DELEGATED REPORT

Application Number: 21/00001/FUL

Application Site: 1 Ewell House Parade, Epsom Road, Ewell, Surrey, KT17 1NP

Proposal: Change of use from Use Class E to Sui Generis (formally A1 to A5) and installation of chimney extractor

PROPOSED CHICKEN SHOP AT 1 EWELL HOUSE PARADE, EPSOM ROAD, KT17 1NP			
Title: PROPOSED FRONT & REAR ELVN	Scale:1:100	Date: 13/09/2020	Dwg:No: TSL/THR/01/05

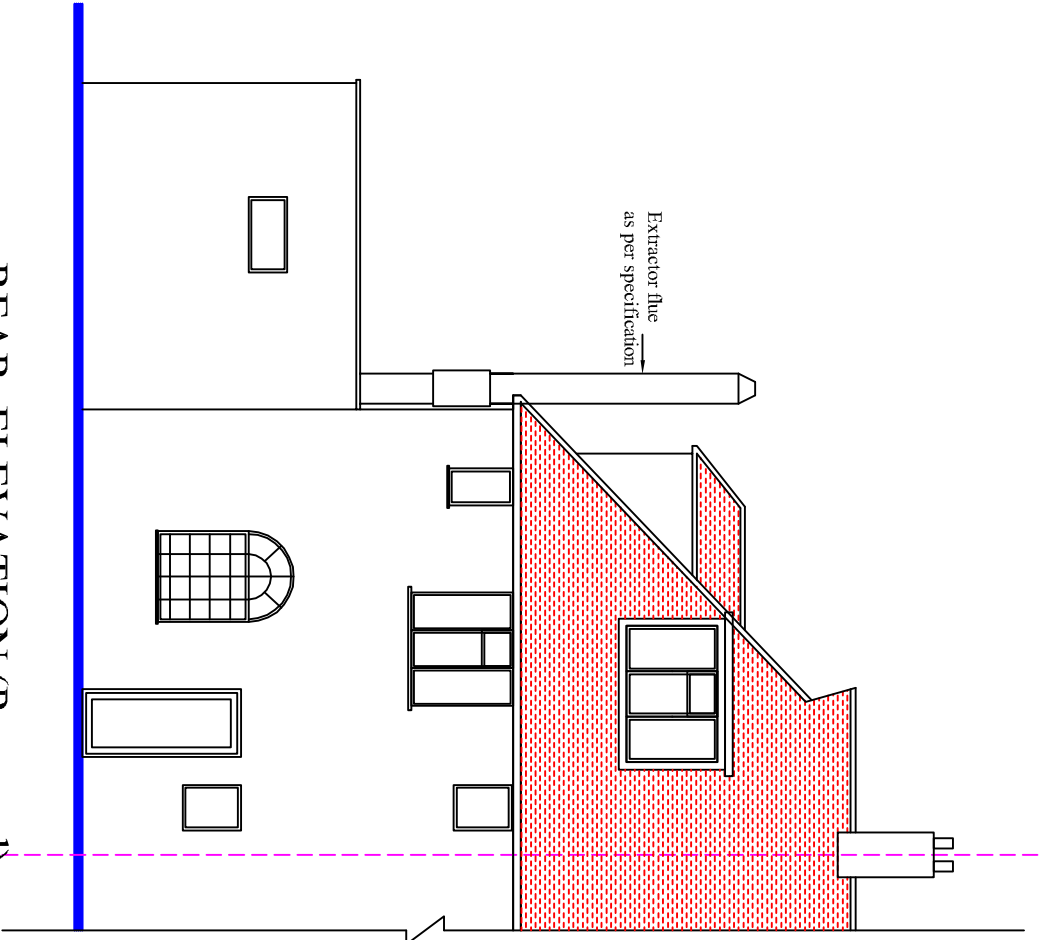
21. The proposed extractor flue would be visible from both Epsom Road/High Street and the footpath named The Grove. The Ewell Village Conservation Area Townscape Appraisal Map identifies the views from both ends of The Grove as important views within the Conservation Area. It is noted that the mature trees along The Grove would help obscure the proposed extractor flue in the summer months, however it would be in full view in the winter months. It would extend well above the eaves of the existing building. The proposed extractor flue, by reason of its design, height and siting, would be a dominant and incongruous addition that would be visually intrusive within the streetscene and would fail to enhance or preserve the character and appearance of the Ewell Village Conservation Area. The harm would extend to the setting of the Grade II Listed Wall located adjacent to the site boundary and along The Grove.

2. The proposed extractor flue, by reason of its design, height and siting, would be a dominant and incongruous addition that would be visually intrusive within the streetscene and would fail to enhance or preserve the character and appearance of the Ewell Village Conservation Area in conflict with the NPPF (2019), Policy CS5 of the LDF Core Strategy (2007) and Policies DM8, DM9 and DM10 of the LDF Development Management Policies Document (2015). The harm would extend to the setting of the Grade II Listed Wall located adjacent to the site boundary and along The Grove. The limited public benefits do not outweigh the less than substantial harm, in conflict with Paragraph 196 of the NPPF (2019).
